WEST SUSSEX COUNTY COUNCIL CONSULTATION

TO:	Arun District Council FAO: Stuart Corbey
FROM:	Highways, WSCC
DATE:	12/02/2019
LOCATION:	46a and 46b Pier Road, Littlehampton, BN17 5LW
SUBJECT:	LU/182/18/PL Demolition of the existing buildings and erection of 2 No. new buildings incorporating commercial (A1) at ground floor with 4 No. new residential units above.
DATE OF SITE VISIT:	20/09/2018
RECOMMENDATION:	☐ Advice ☒ Objection ☐ Modification ☐ No Objection ☐ More Information ☐ Refusal
S106 CONTRIBUTION TOTAL:	£N/A

drawing **Proposed site plan**

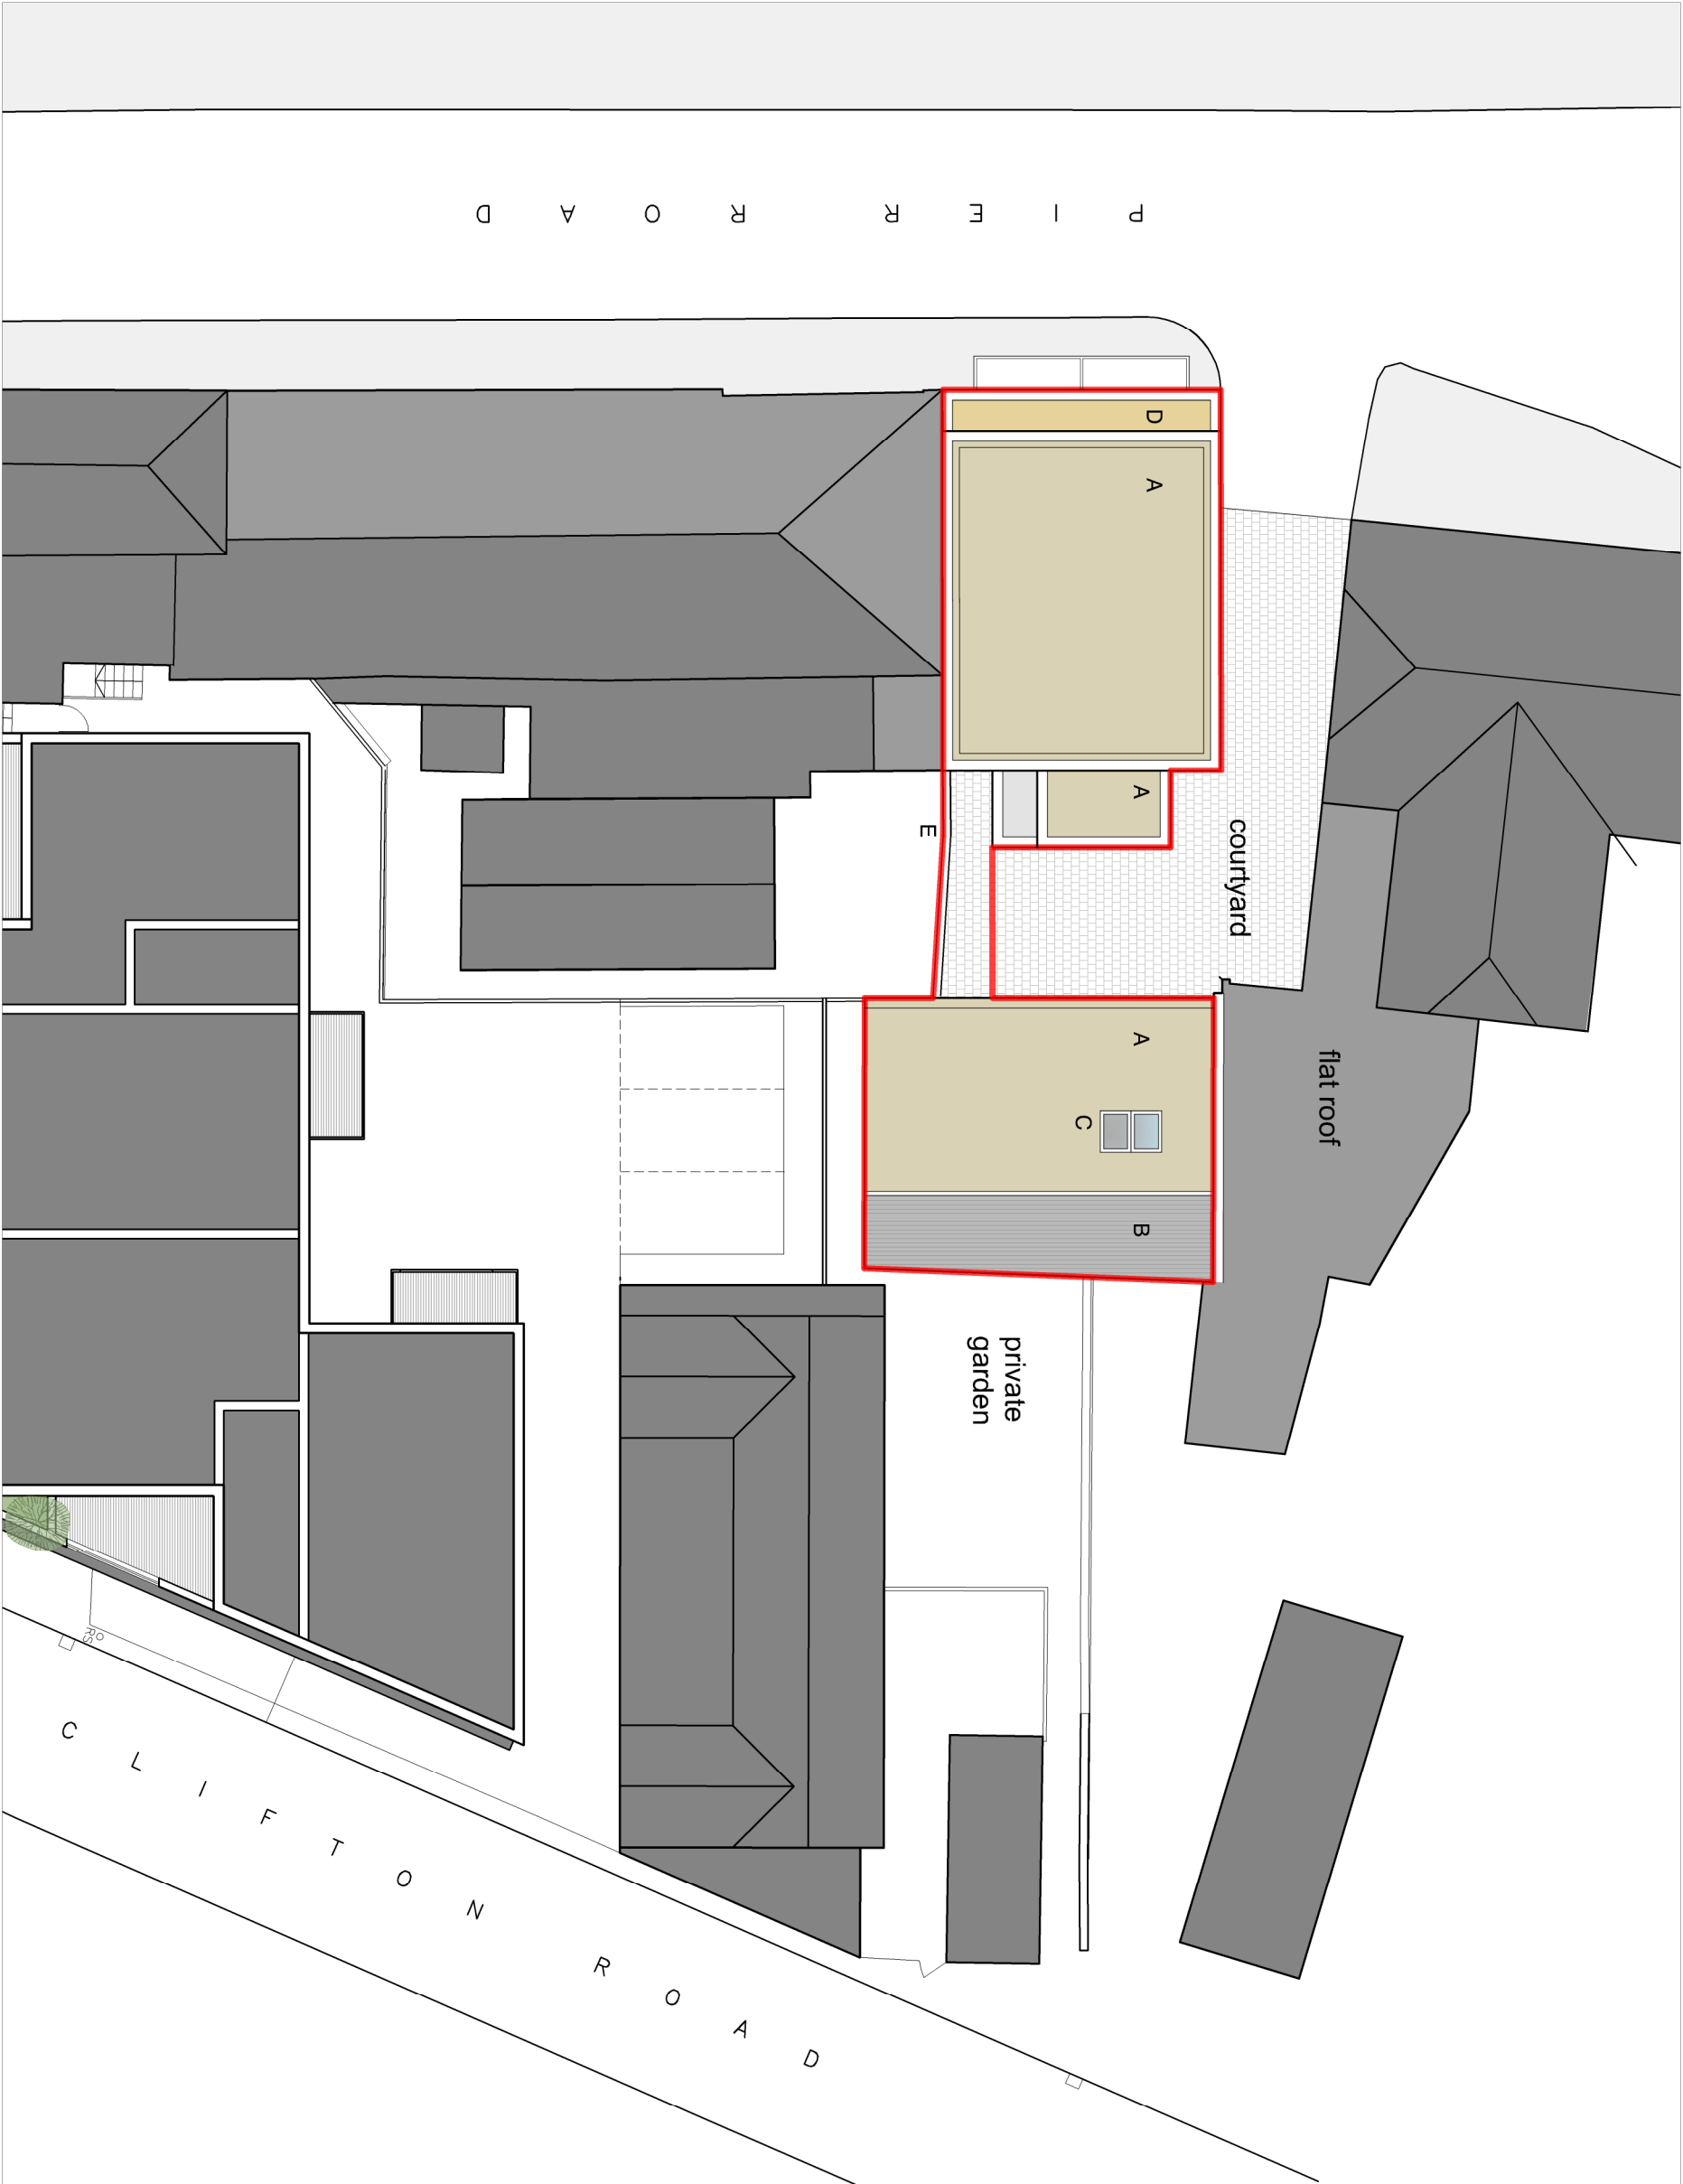
The LHA has been re-consulted on this application following the submission of revised plans and elevations, including a revised site plan.

The applicant was requested to provide maximum achievable visibility splays at a 2m X distance. Manual for Streets (MfS) sets out a minimum sight stopping distance of 43m for a 30mph road. The revised plans demonstrate maximum achievable visibility of 2m x 32m to the north and 2m x 12.5m to the south. Visibility to the south has been demonstrated as severely substandard for the anticipated road speeds. A reduction in visibility splays can be accepted when a speed survey has been conducted demonstrating 85th percentile speeds in accordance with the achievable visibility splays. A speed survey has not been undertaken to support visibility splays of 12.5m to the south of the access. Visibility splays of 12.5m would equate to road speeds of 11mph - the LHA does not anticipate that vehicles would be travelling at these speeds in this location.

The applicant proposes to provide three covered parking spaces for the residential use. The applicant was previously requested to provide swept path tracking in order to demonstrate that vehicles can manoeuvre in and out of the proposed spaces and turn on site in order to exit onto the public highway in a forward gear. The applicant has not provided swept path tracking and as such has failed to

demonstrate that vehicles can turn on site. The LHA would not support vehicles reversing onto the public highway in this location due to the severely substandard visibility at the access.
